Rezoning Transportation Analysis

Petition Number: 2025-063

Revision Log:

Date	Description
6-25-25	First Review (NK)
8-20-25	Second Review (NK)

RZ1.00

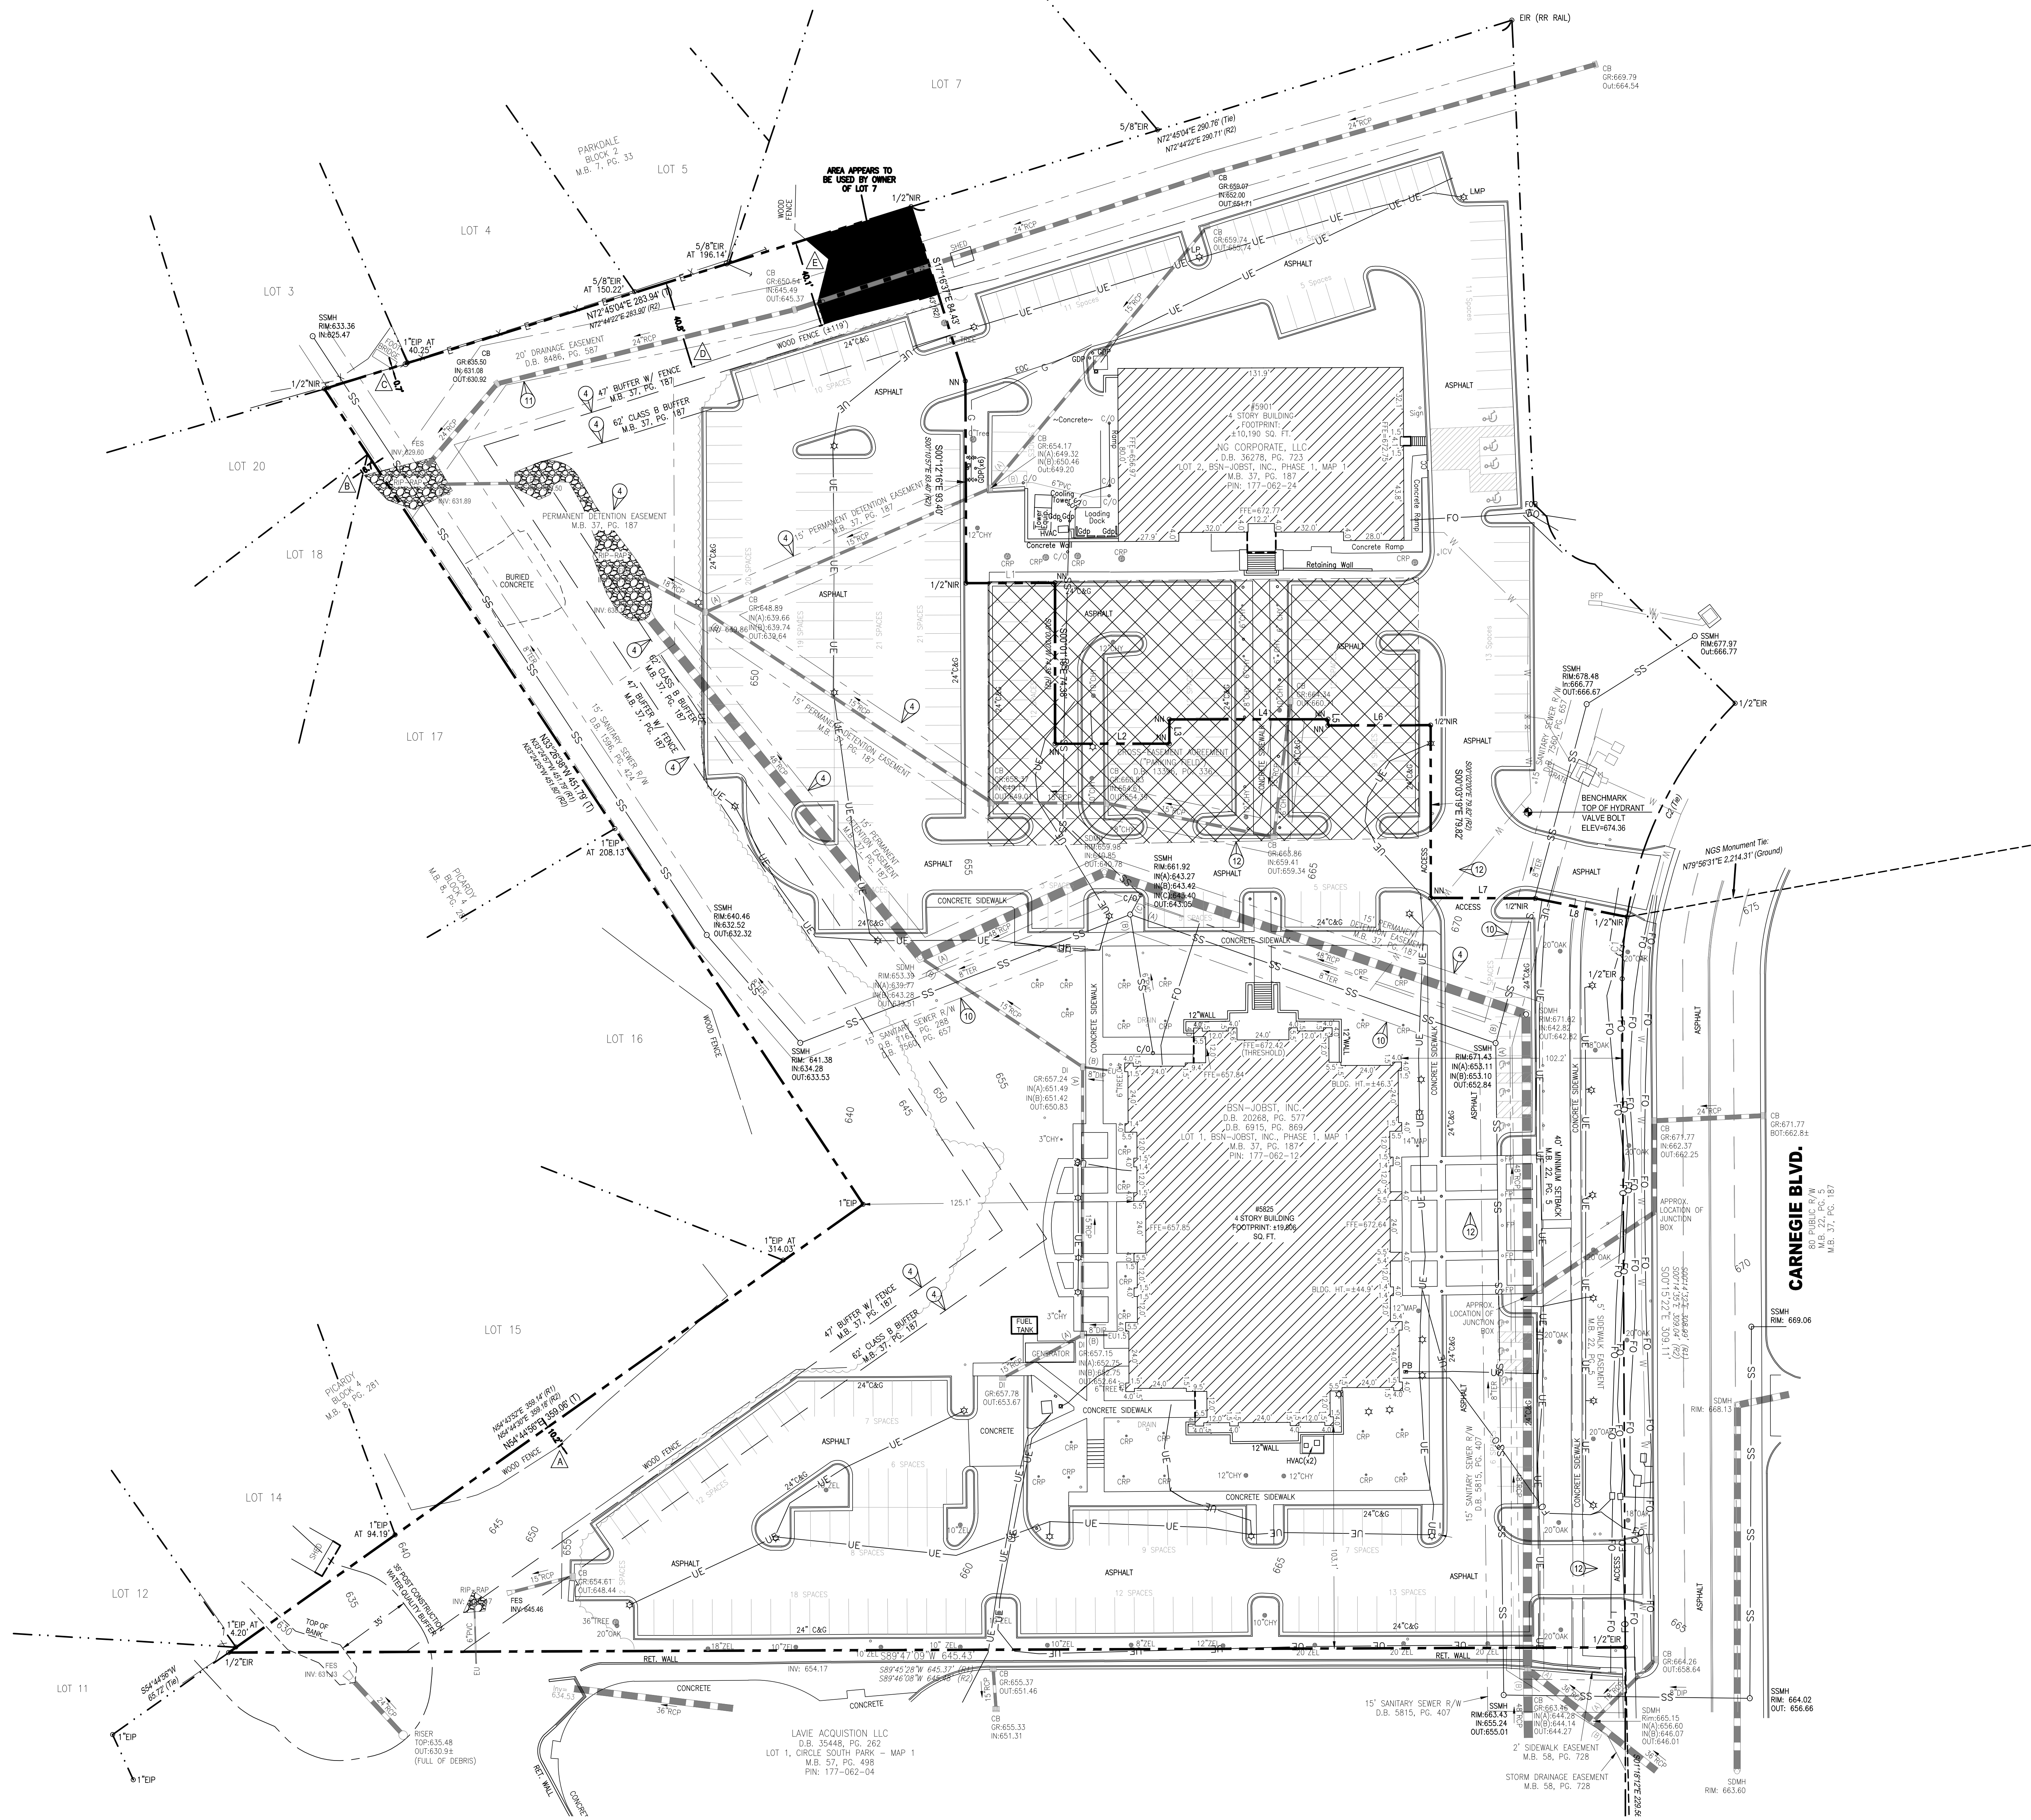
2. Comprehensive Transportation Review (CTR):

The petition's zoning falls within the medium to high intensity development which based on the 1,671 daily trips will trigger Tier 3 (14 mitigation points) for multimodal assessment and Tier 3 (6 mitigation points) for transportation demand management assessment. The petitioner shall review and assess the publicly accessible pedestrian network within ¼ mile walking distance of the site to identify multimodal infrastructure to meet the Tier 3 (14 mitigation points) for multimodal assessment. Petitioner shall also provide transportation demand management strategies to meet Tier 3 (6 mitigation points) to reduce vehicle trips and encourage alternative modes of transportation.

Complete CTR summary table and include on the revised plan. CTR table link (use Site Data Table – CTR Summary tab): <https://www.charlottenc.gov/files/sharedassets/city/v/2/growth-and-development/documents/dev-center-fees/resources/udo-site-data-tables-curb-ramps-and-ctr.xlsx>

Clarifying Comment 8.20.25: Site will trigger Tier 3 multimodal and TDM. Add conditional note that says, "Site will comply with CTR requirements to be finalized in permitting."
